Littlehampton – LU/212/17/RES

Response to consultee comments in blue:

drawing number	rev.
A/PHLITTLE-INT.1/TK-1	P6

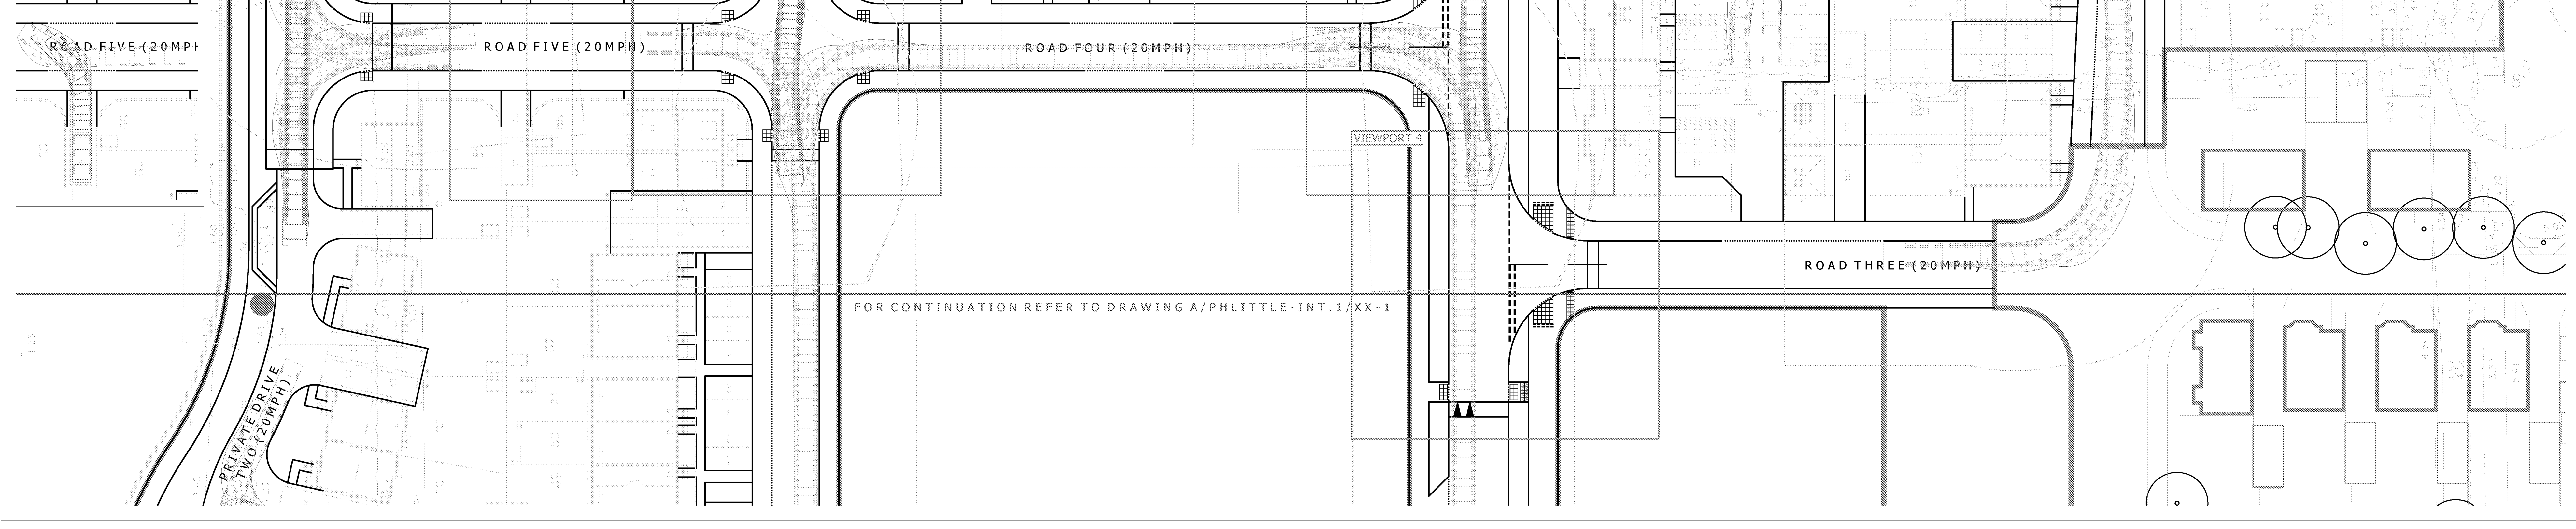
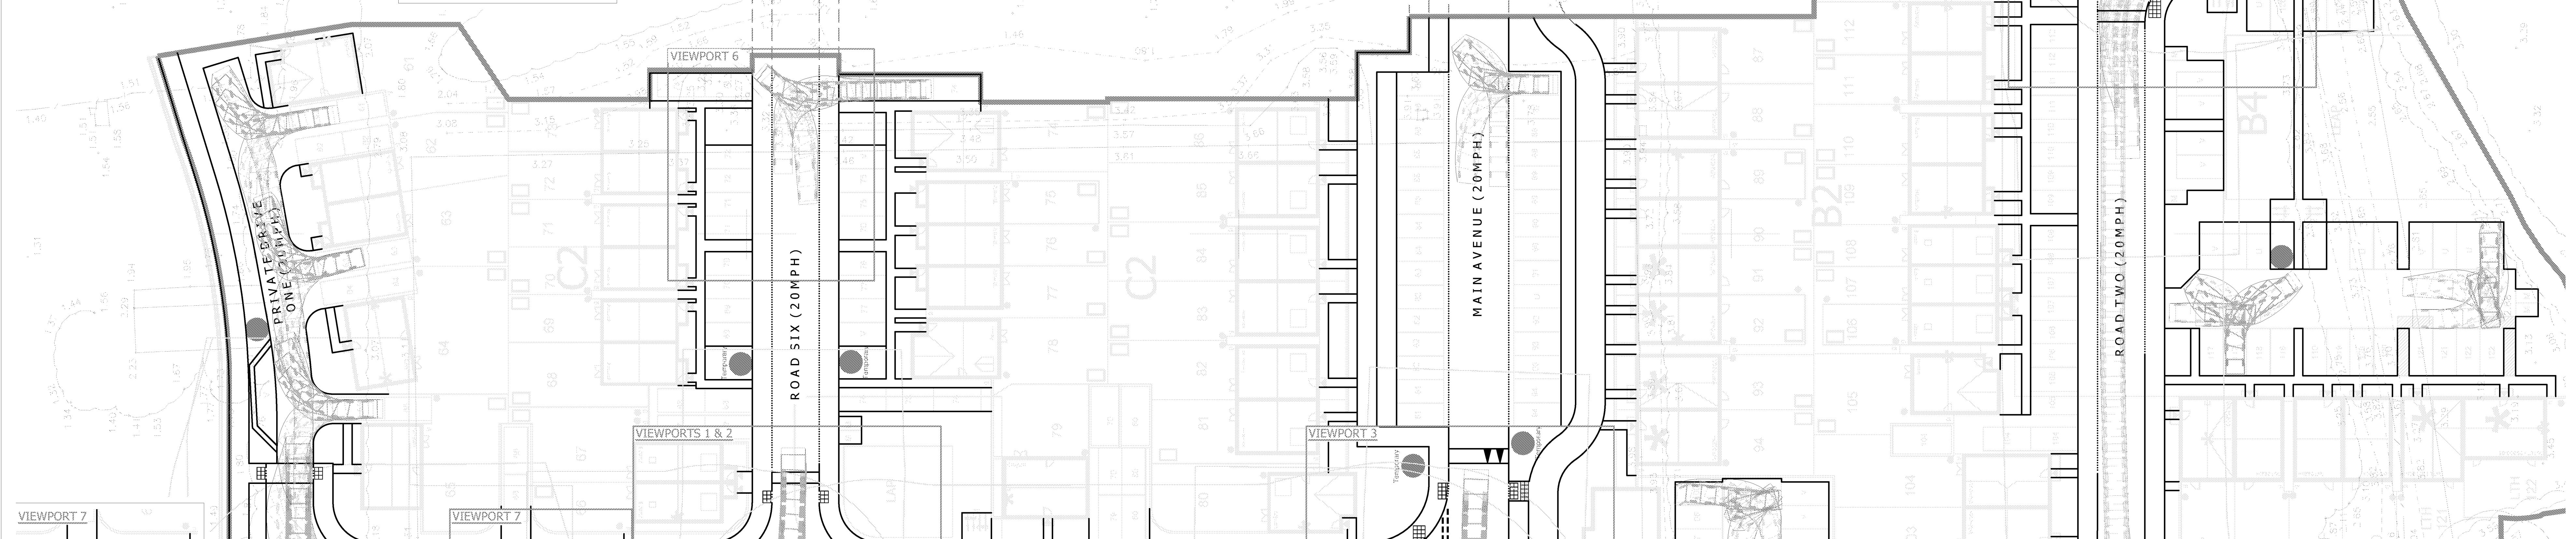
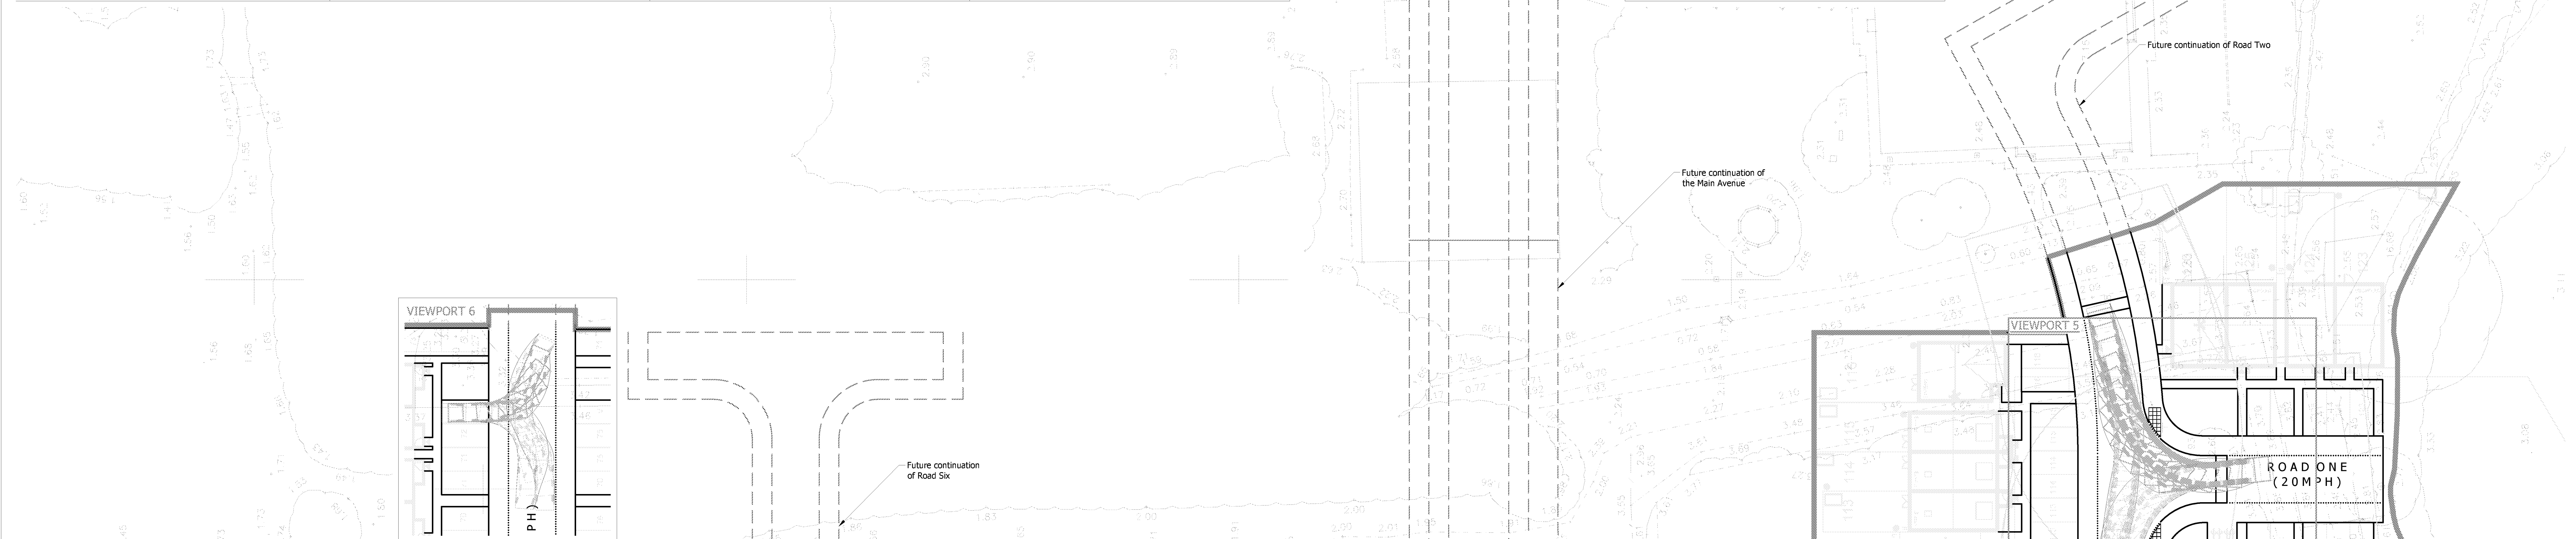
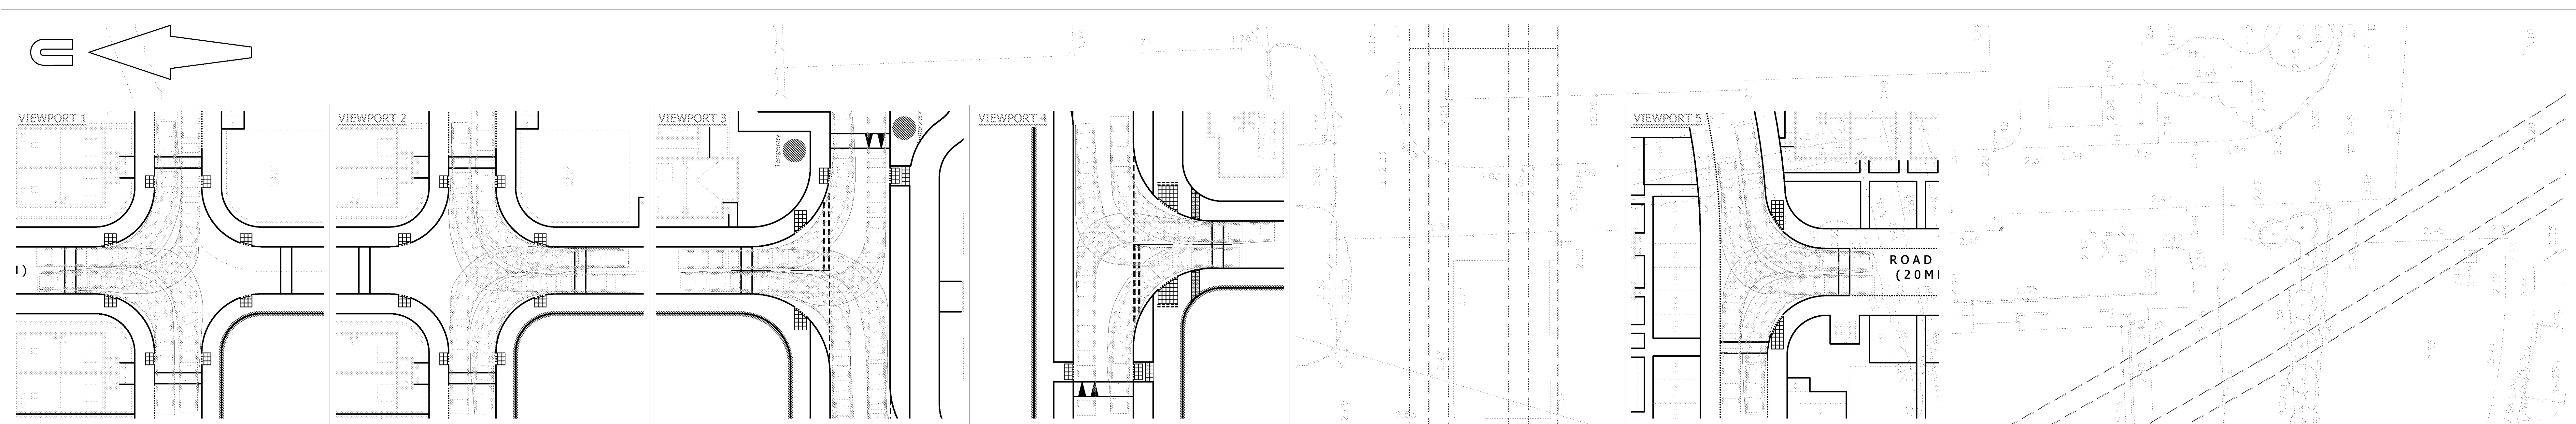
(3) Tracking of refuse and fire vehicles to Plots 95-100 and 117-122 shows overriding of access points to the main carriageway and over-sailing of the footway opposite. Or else consider bin stores located within suitable distance to the main access roads.	(3) We have removed the refuse turning in these areas and introduced bin collection areas instead.
